**APPLICATION FOR THE PROPOSED ABLE ENERGY MARINE PARK DEVELOPMENT
CONSENT ORDER**

**COMMENTS ON THE APPLICANT'S WRITTEN SUMMARY OF THE APPLICANT'S
CASE AT THE SPECIFIC ISSUE HEARING ON THE DCO HELD ON 12 JULY 2012
("the Written Summary")**

**SUBMITTED ON BEHALF OF NETWORK RAIL
INFRASTRUCTURE LIMITED**

Planning Inspectorate Reference Number: TR030001

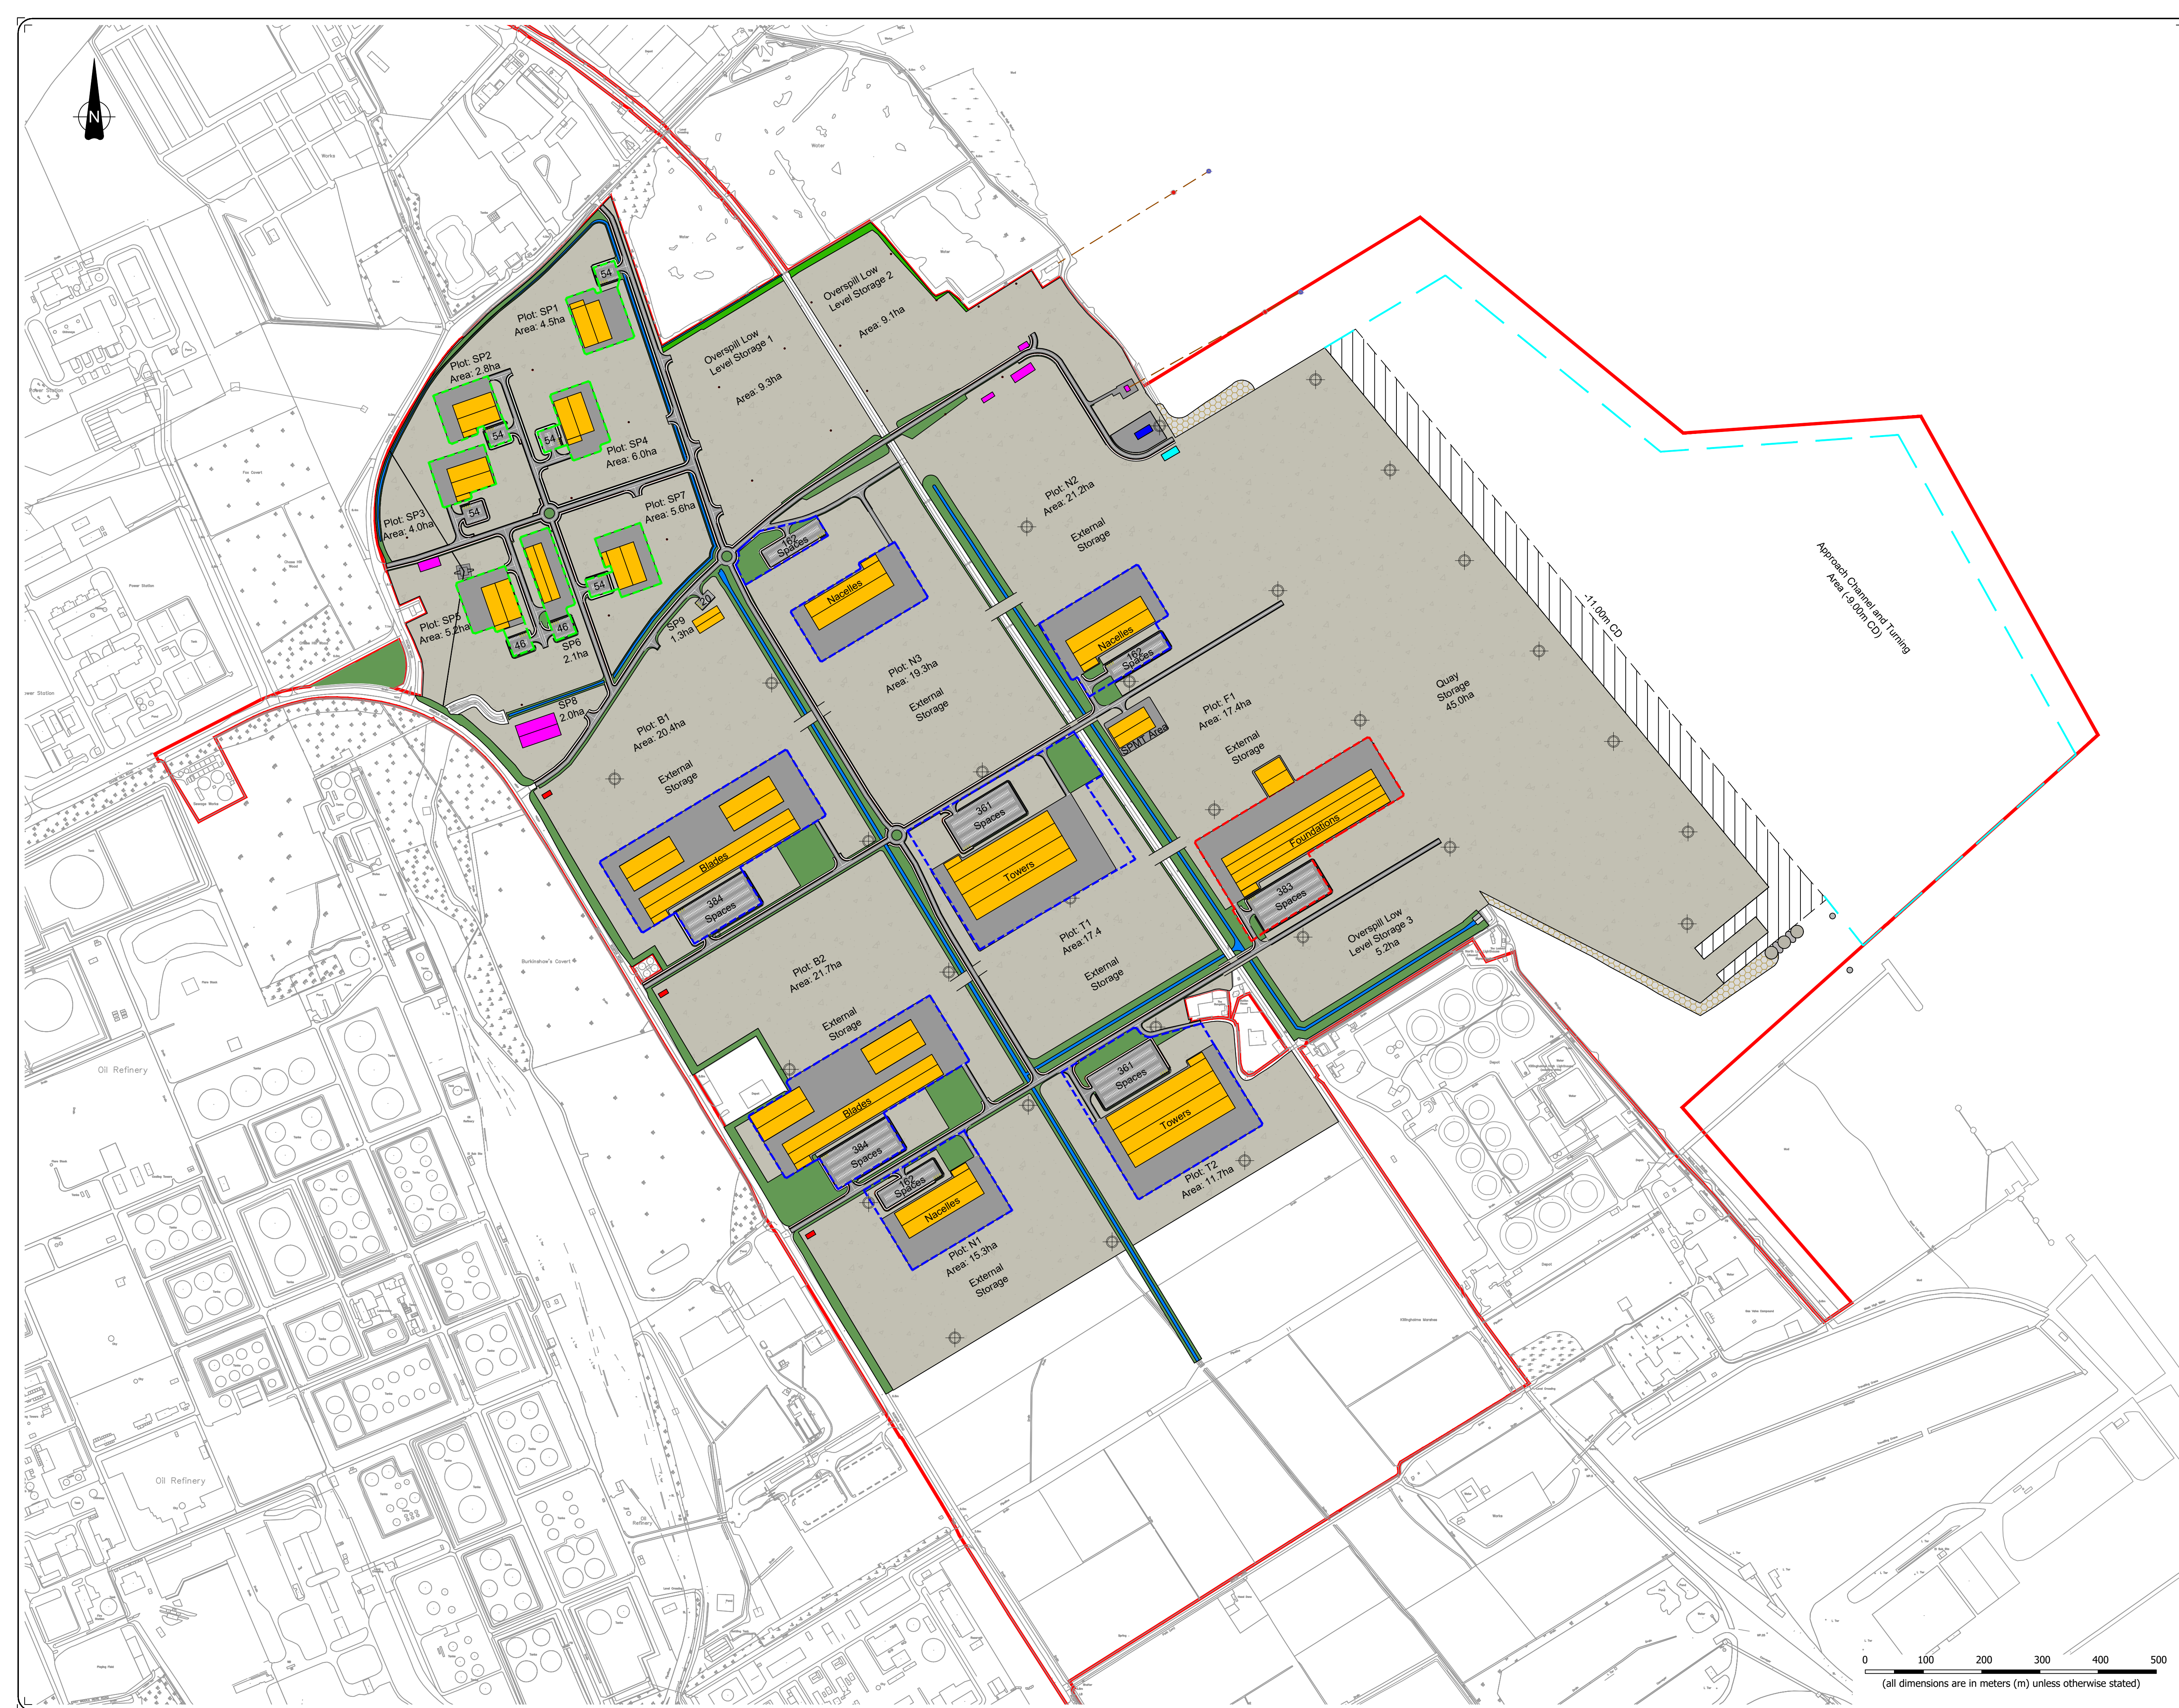
1.4 Representative in attendance on behalf of NR explained that the precise nature of the works were unclear and that although the explanatory memorandum referred to there being no physical works, the masterplan drawings showed several level crossings which Network Rail could not agree to for safety reasons. The Applicant commented that draft DCO contained provisions for creating new railway and that this would allow them to create new sidings. Network Rail consider this to be physical works. At the hearing, Network Rail reiterated its fundamental objection to new level crossings detailed in the Written Representation, which are against the policy of both Network Rail and the Office of Rail Regulation (Network Rail's safety regulator).

1.5 The Applicant was requested to provide additional detail on the proposed physical works to the railway.
